From: Tim Townsend [REDACTED]
Sent: 26 January 2022 11:00
To: [REDACTED]
Cc: 'dave.tighe' [REDACTED] Simon Davis <Simon.Davis@arun.gov.uk>
Subject: RE: 2087 - Woodgate - AL/129/21/OUT - Response to highway officer consultation including design audit and departures from standards

A	Updated site access arrangements	BL	10.02.22
ISSUE	REASON FOR REVISION	BY	DATE

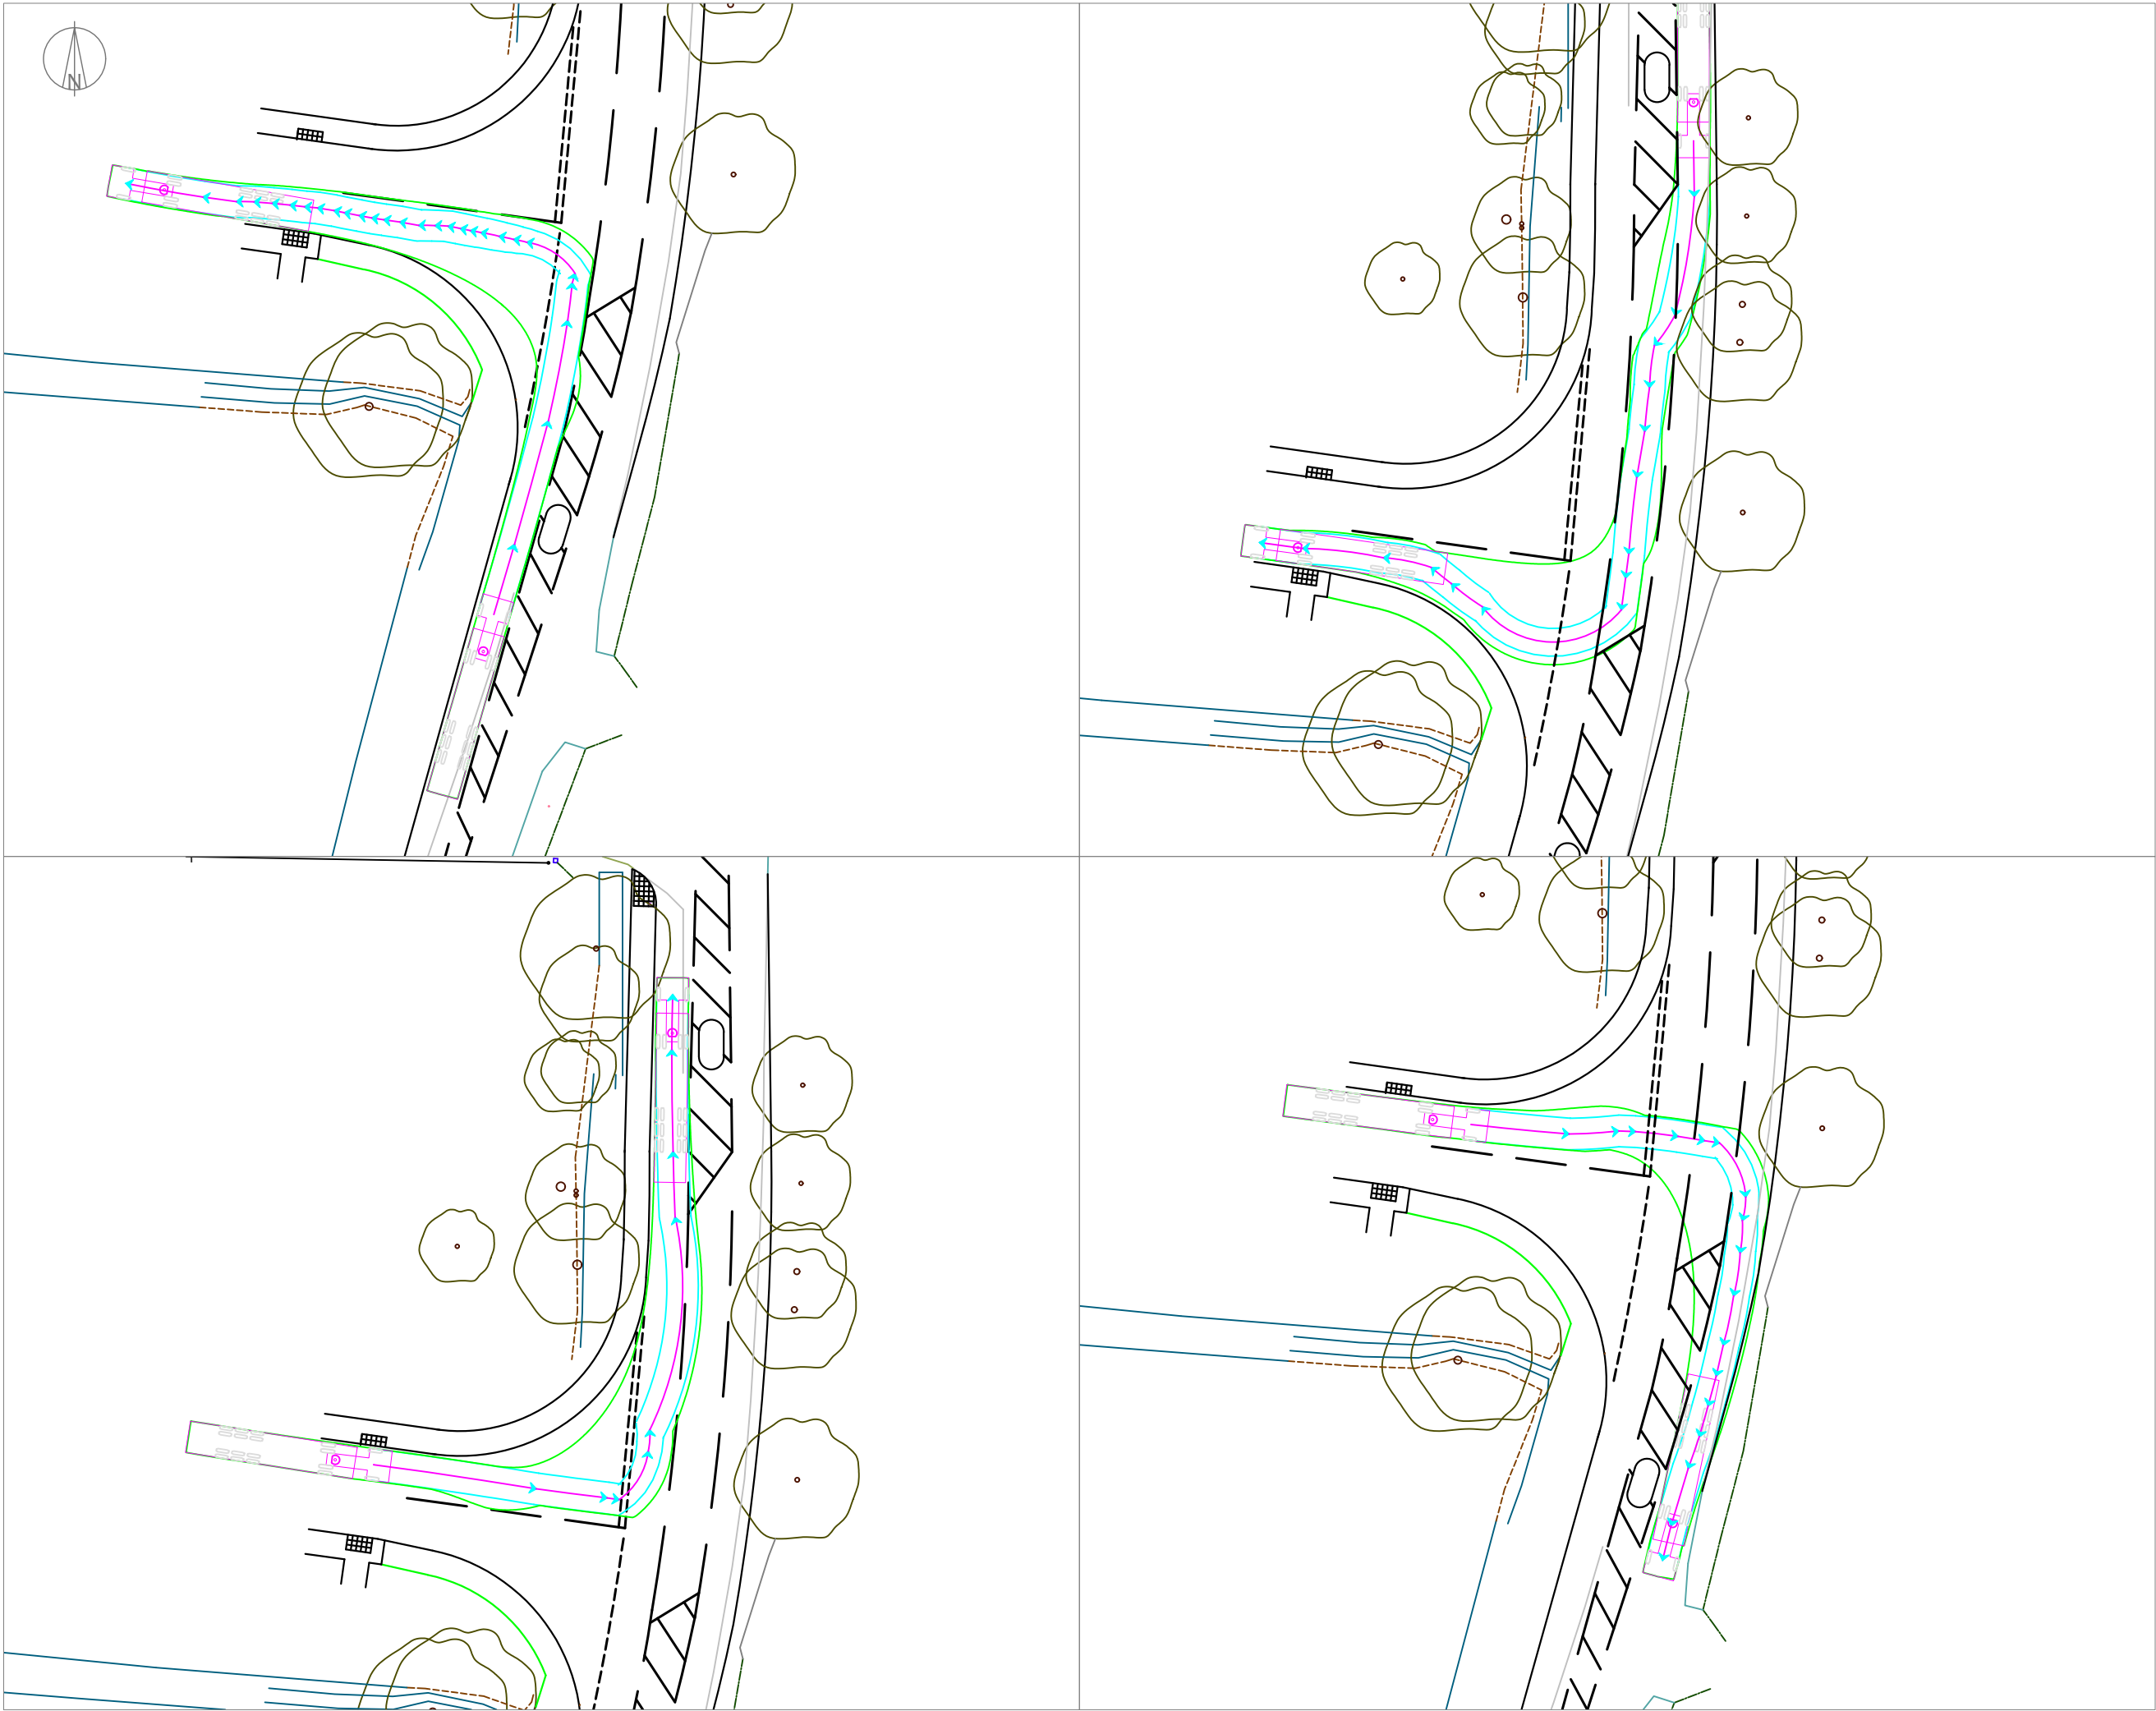
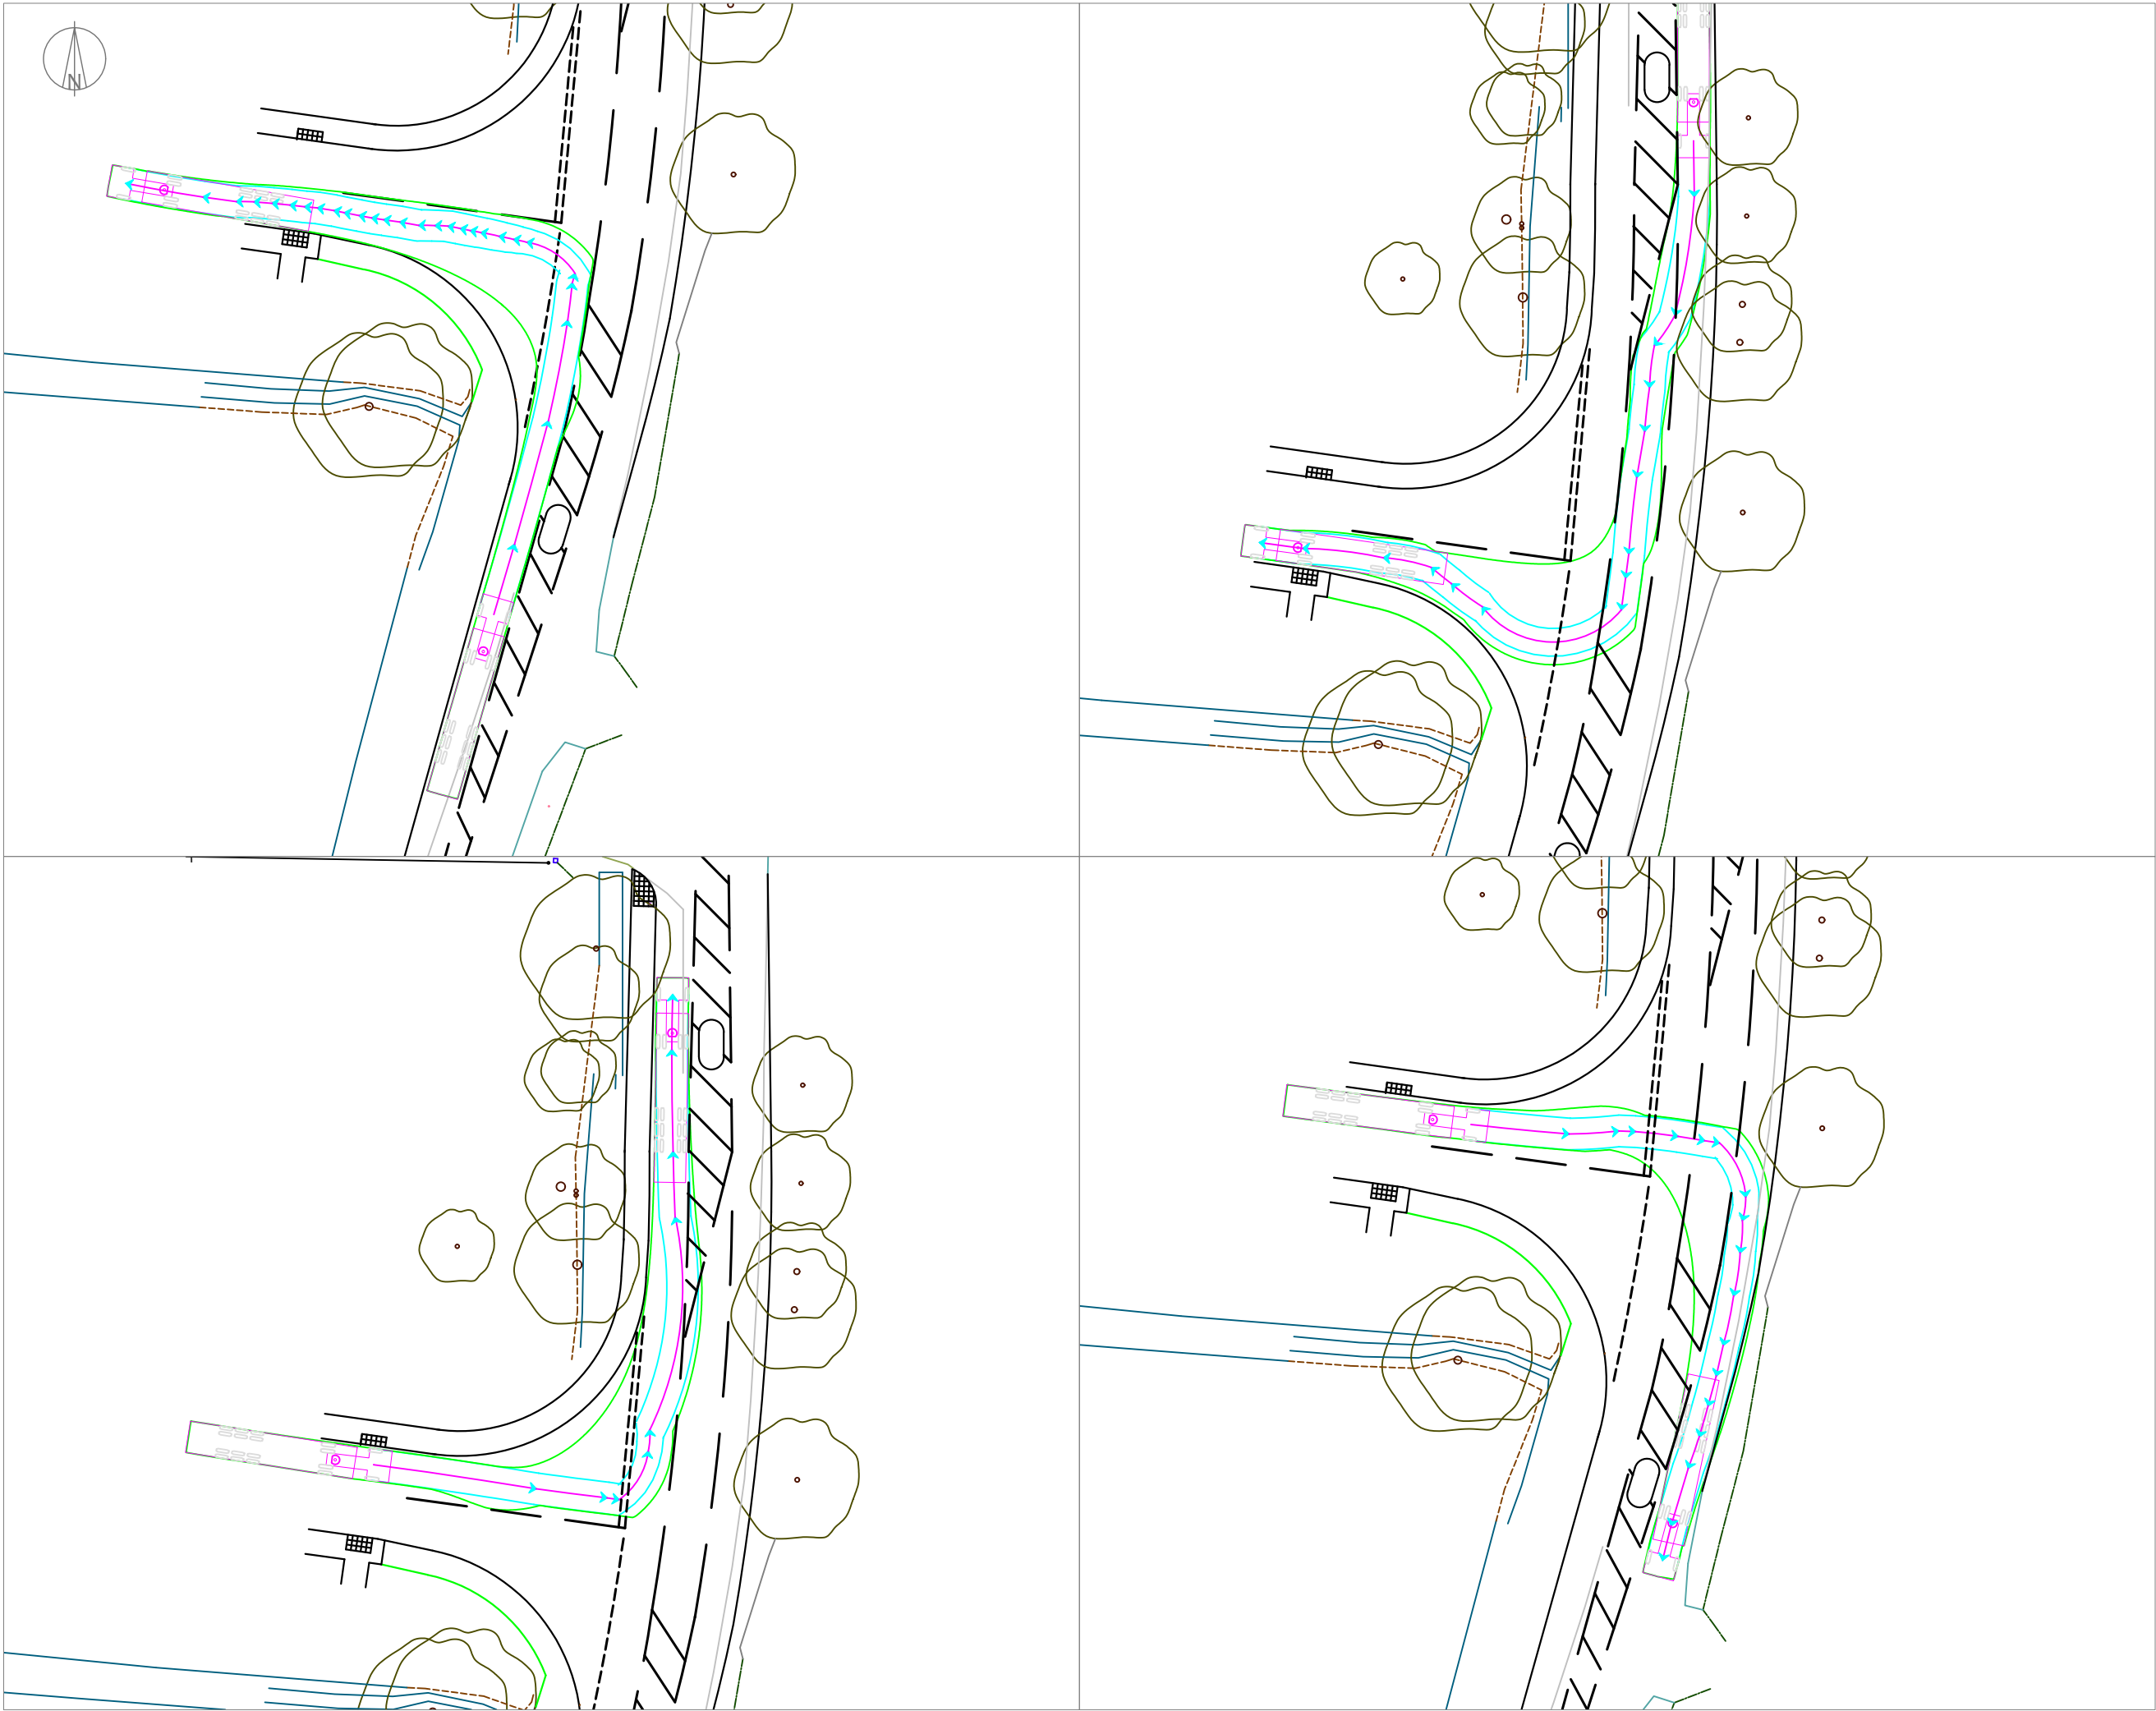
1. *Cycle connection (on eastern side of A29)* – You've shown a cycle connection on the western/site-side of the road coming out of the corner of the development but you haven't shown anything on the opposite side of the road to cater for southbound cyclists attempting to leave the carriageway, then lining-up to cross the road and then entering the development. For the avoidance of doubt, are you referring to the secondary pedestrian/cycle access in the northern part of the site? *Yes, I am. You've not shown any works on the opposite side of the road (eastern-side of A29) to cater for cyclists travelling south along the A29 and then wishing to leave the carriageway – cross the road – and then enter the site.*

2. *Retained 'central' access to farm house* – You mention that sight lines would be approximately the same as previously. However, you don't appear to have marked those on any of the amended plans. For the avoidance of doubt, is the farmhouse you refer to Woodgate House that the site wraps around. *Thanks for the clarification of the property name. And yes, it's the sight lines from that retained access that I want to see on a further plan, please.*

6. *Access and sight lines* – Please confirm (and show on a plan) that the access and associated visibility splays and widening works required to deliver the access can be delivered using land in your client's control and/or highway land.
